Site Plan Drawing_V2.pdf Markup Summary

VENETUCCI FARMS

A PORTION OF THE SW $\frac{1}{4}$ OF THE SW $\frac{1}{4}$ OF SECTION 11 AND A PORTION OF THE NW $\frac{1}{4}$ OF SECTION 14, EL PASO, COUNTY
 5202 HWY 85-87, 5210 HWY 85-87, 5304 HWY 85-87 & 5304 HWY 85
SPECIAL USE PERMIT - BUSINESS EVENT CENTER

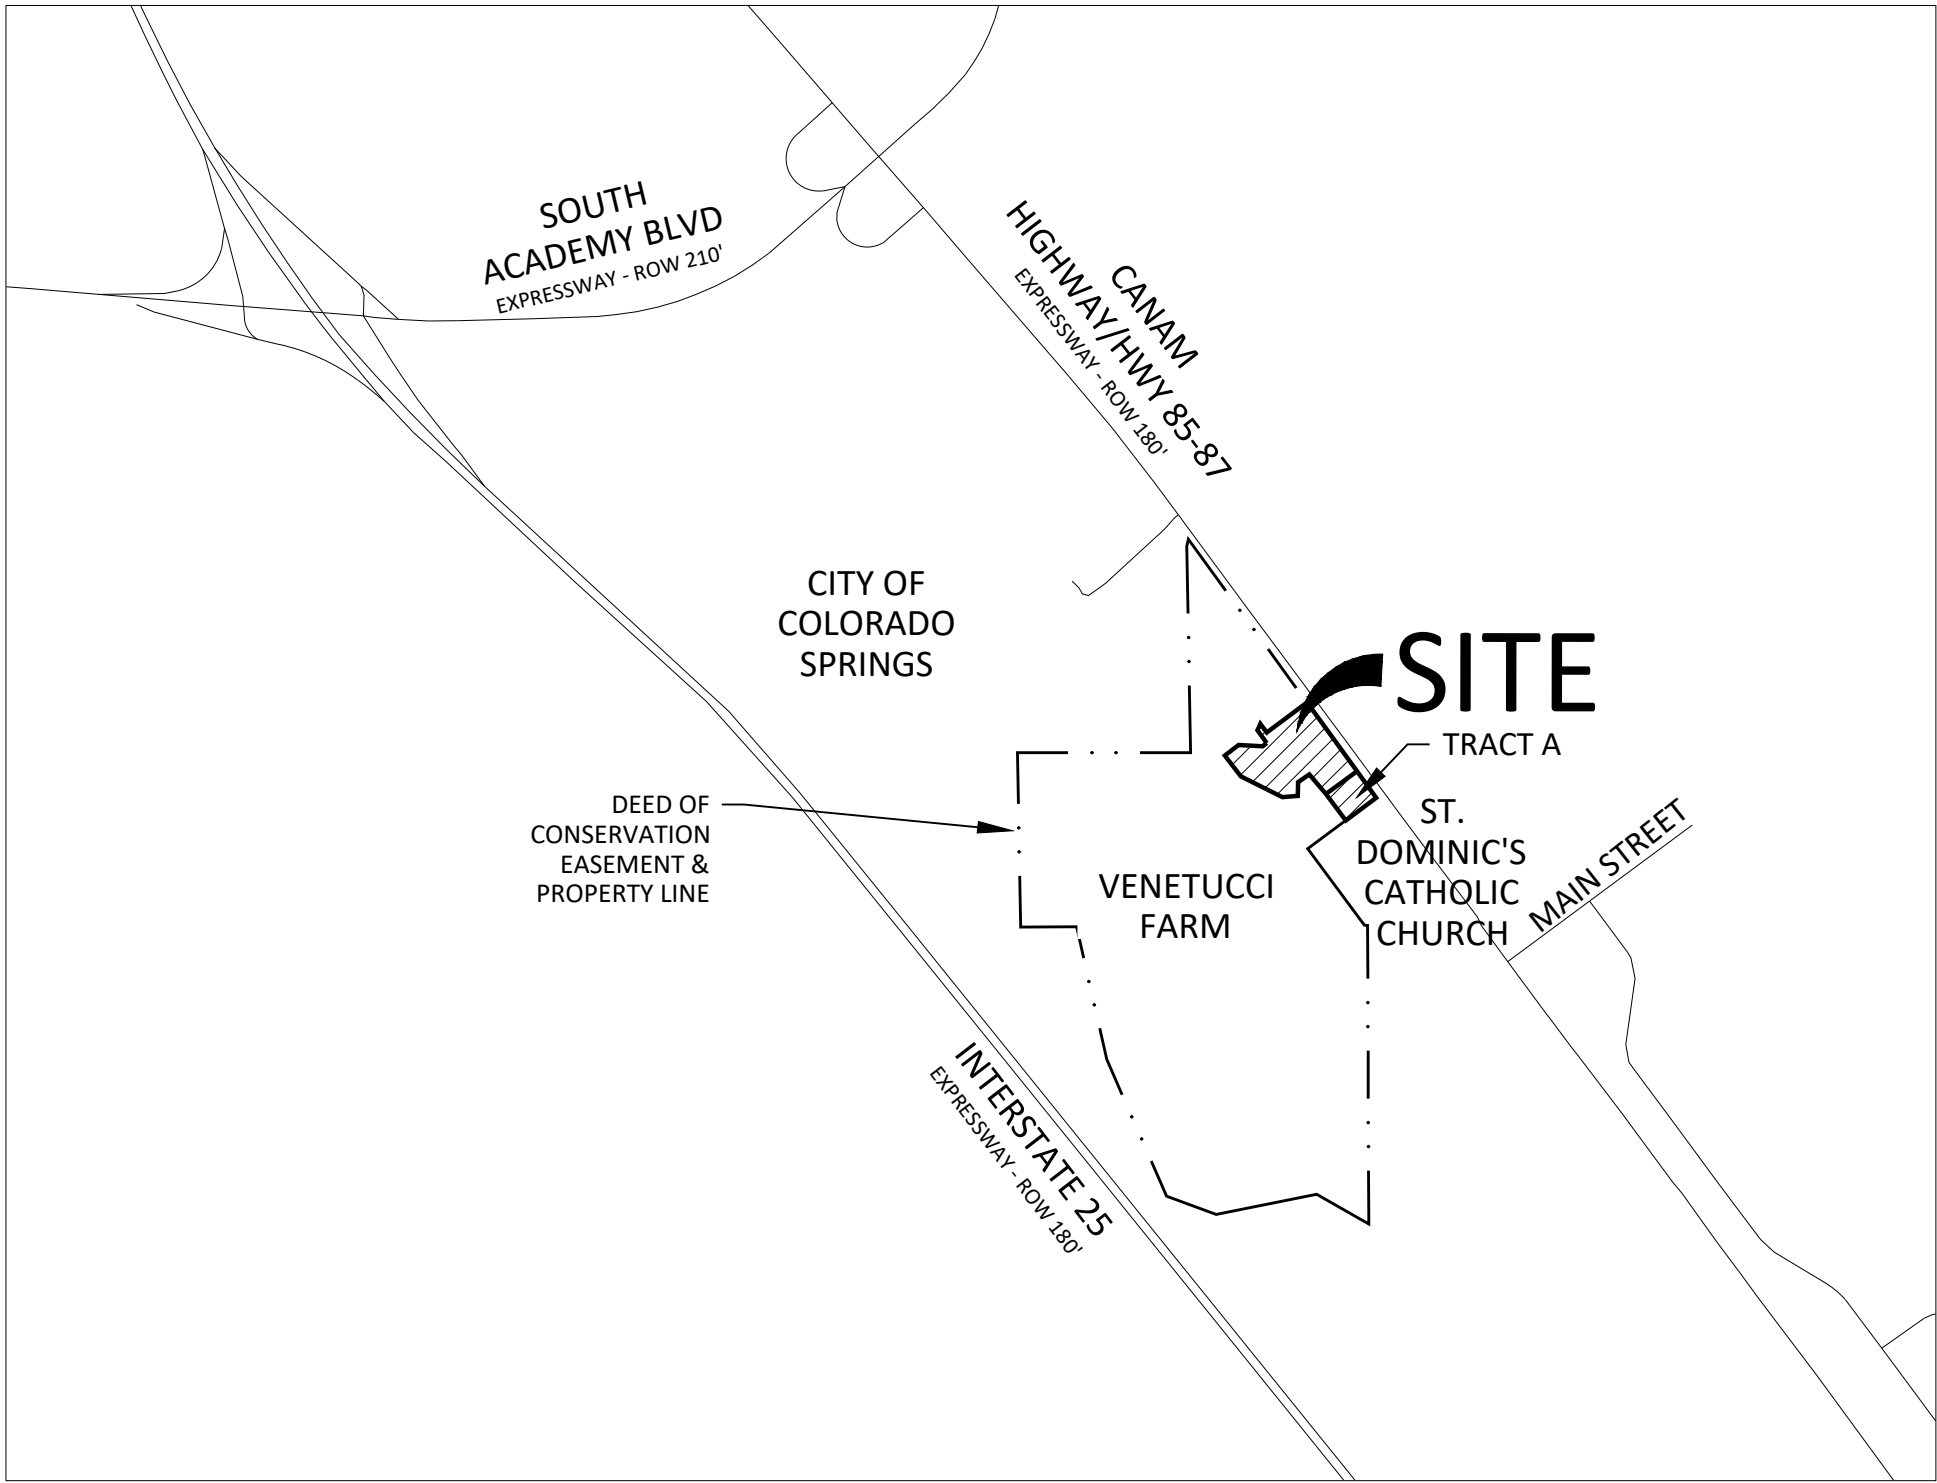
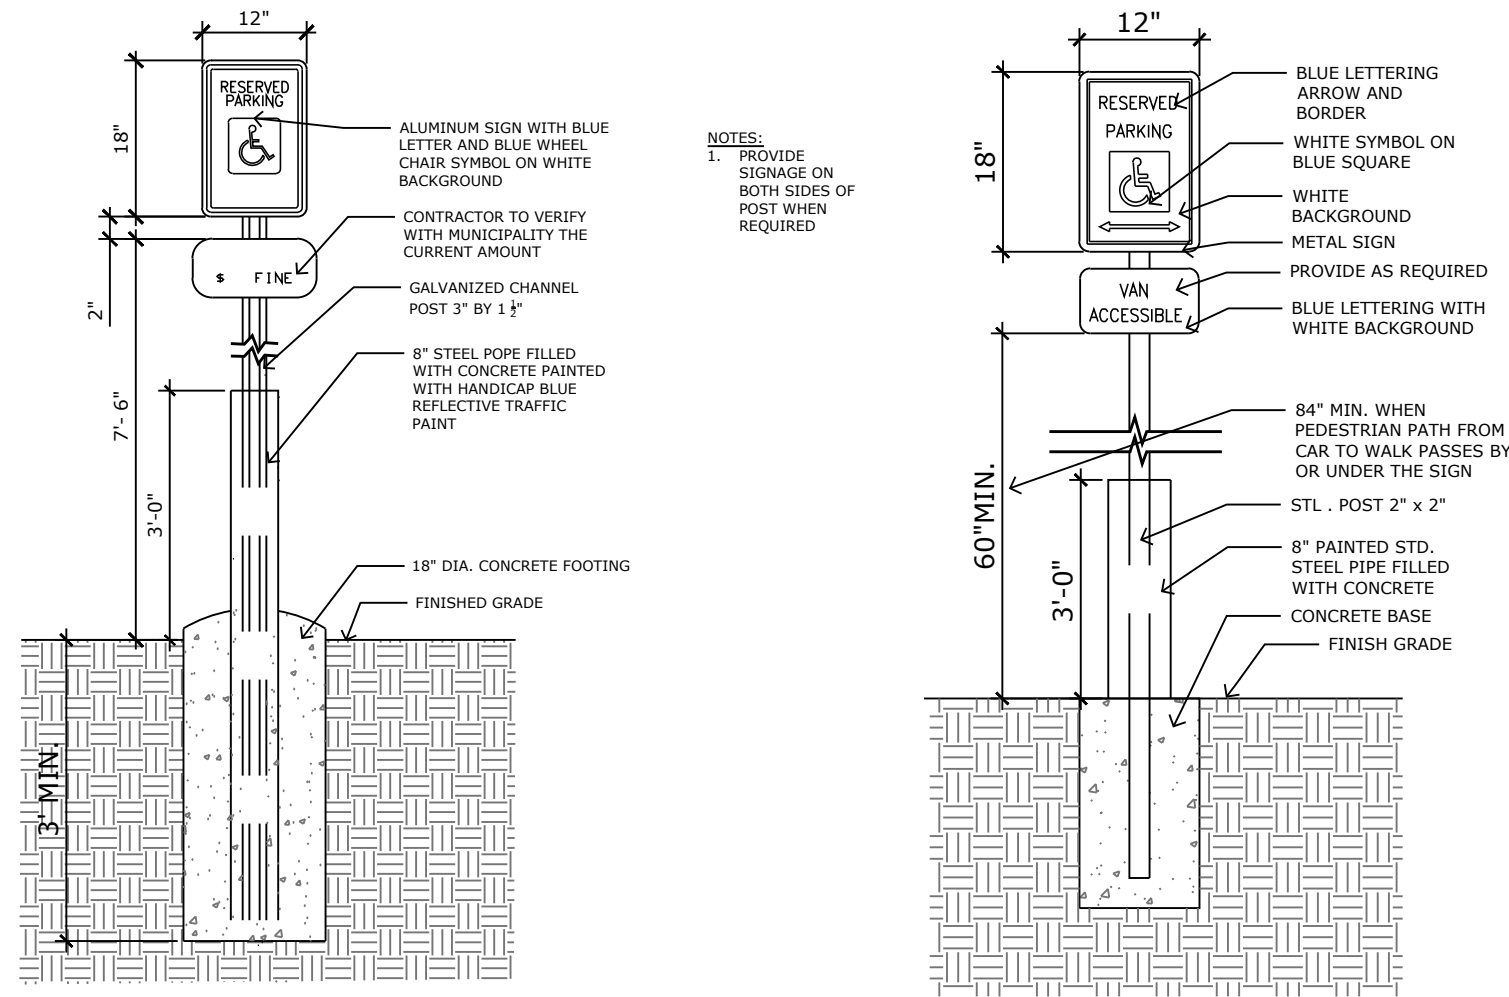
Include percent of open space, landscaping and lot coverage on plan.

Only 3 ADA parking spaces shown on plan. Please revise.

Only 3 ADA parking spaces shown on plan. Please revise. The site plan has been revised to show 4 ADA parking spaces

Include percent of open space, landscaping and lot coverage on plan. This has been added.

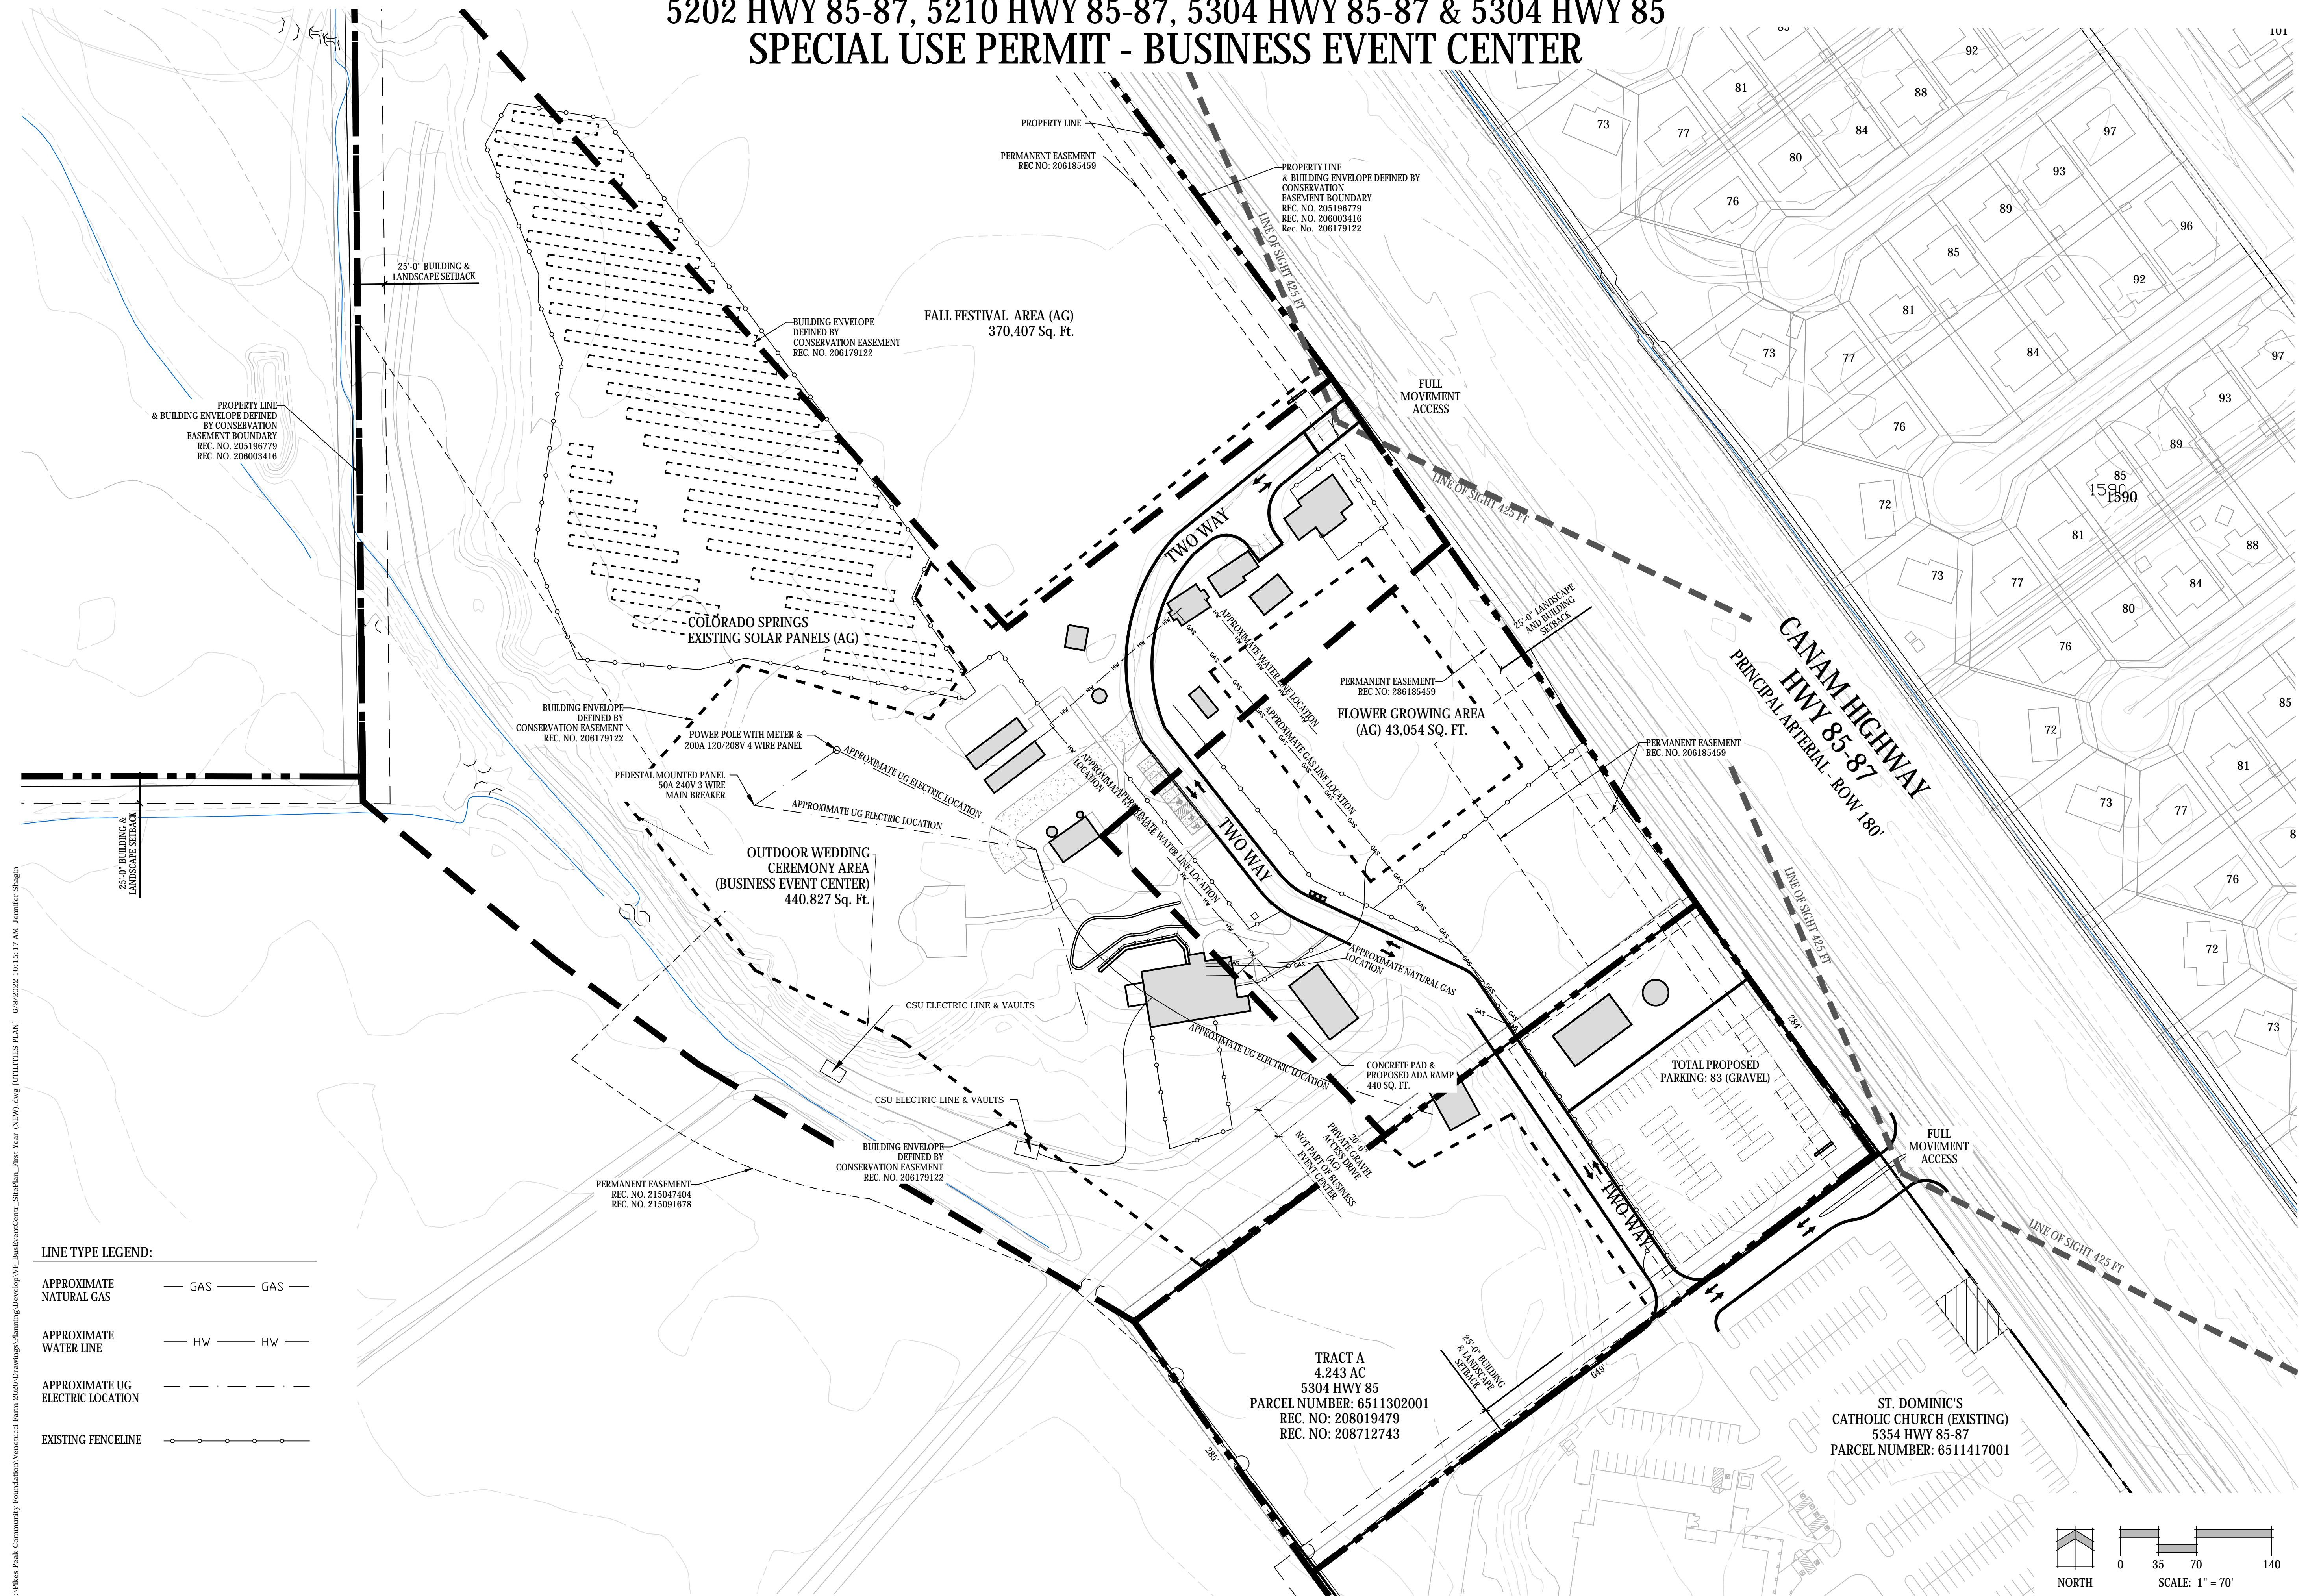
Show location, height and intensity of all outdoor illumination on plan.

Existing exterior lighting is shown on the event barn. All other lighting associated with the Business Event Center will be temporary under 6.2.3(D) of the EPC Land Use Code.
